Response to Submissions

State Significant Development Application (SSD 7500) Proposed Warehouse & Logistics Hub

5 & 9 Culverston Road, Minto (Lot 3 in DP817793 & Lot 400 in DP87511)

Table 1: Response Matrix

Drawing Title: **SITE MASTERPLAN (OVERALL)**
Drawing Number: **116101_A_SSD_A0006**

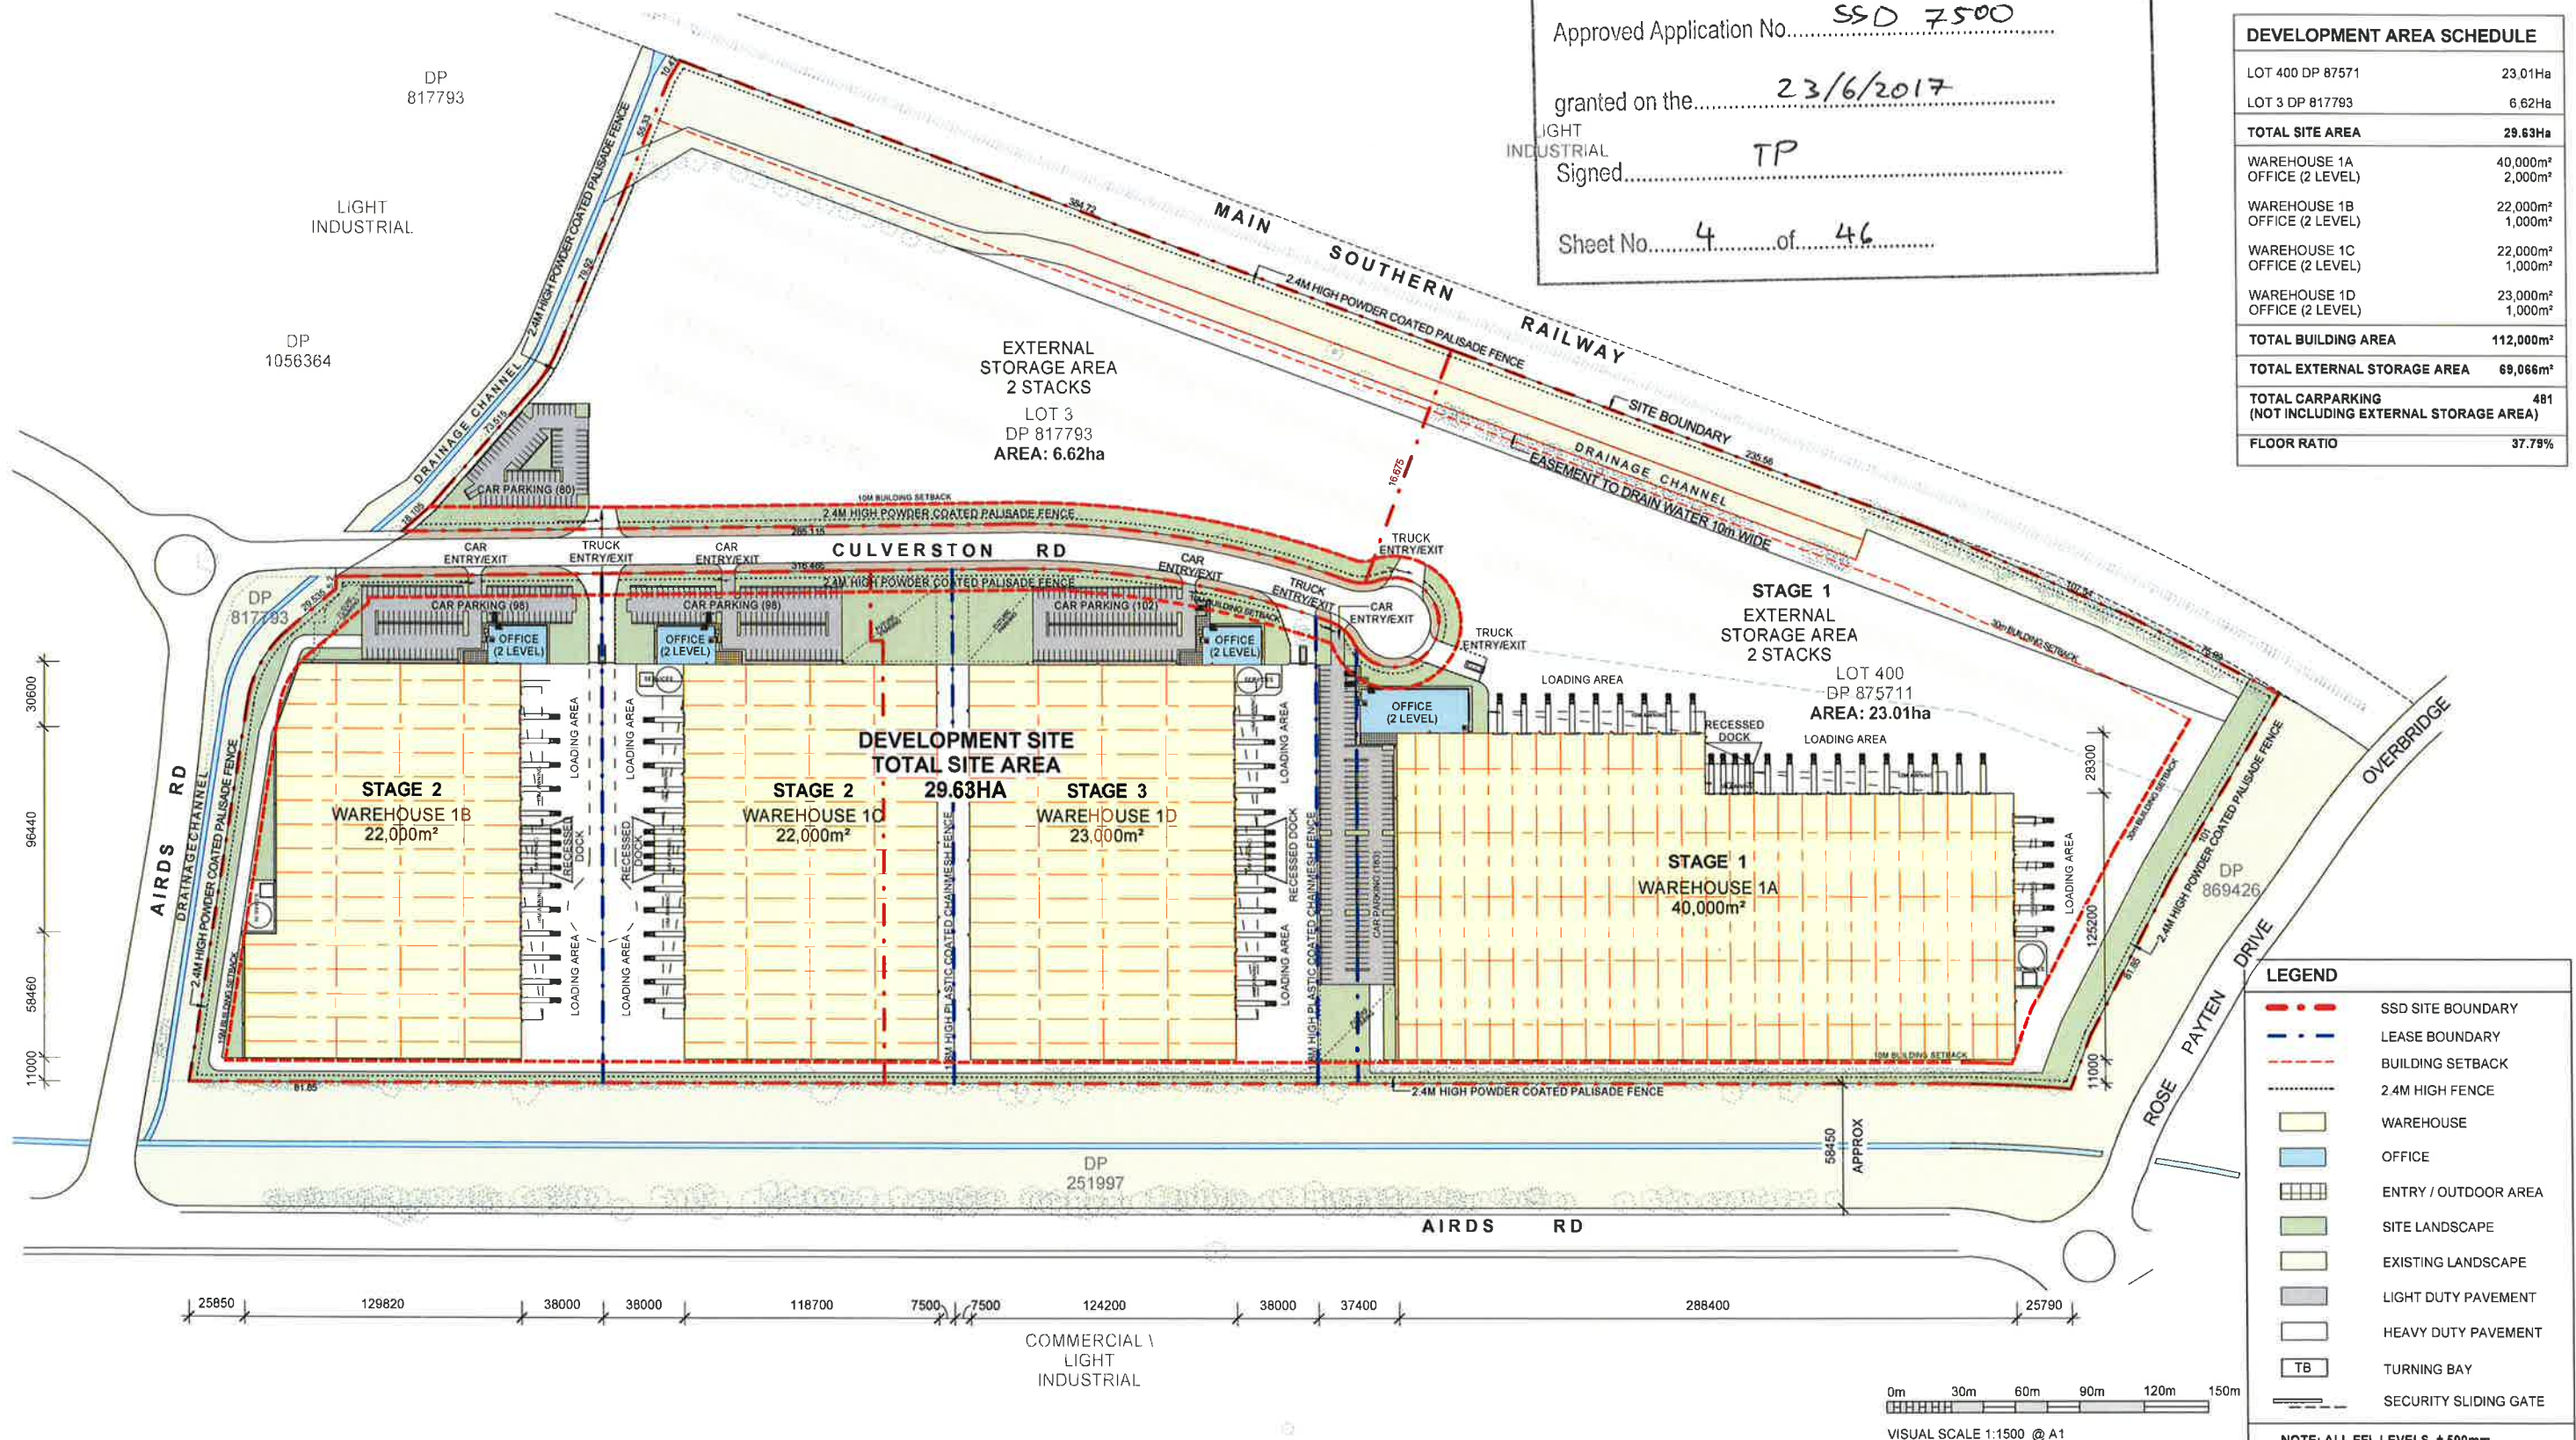
Agency/Council	Response
1. NSW Department of Planning & Environment	
<i>Updated swept paths are to be provided which show that there is no vehicle conflict at Culverston Road with vehicles exiting the site with overflow car park entry/exit. Detail is also to be provided with respect to any gatehouses proposed.</i>	<p>An updated swept path analysis has been provided (Appendix 1) which shows that the driveway onto Culverston Road from stage 2 of the proposed development has been widened and that B-Doubles can exit the site without impacting vehicle movements on the opposite side of the road. To avoid vehicle conflict with vehicles entering/exiting the overflow car park area, the driveway has been widened to facilitate additional turning provision.</p> <p>The site plan has been amended to show the gatehouses and each truck entry, with sufficient queuing distance for vehicles provided so that there is no impediment to the flow of traffic on Culverston Road.</p>
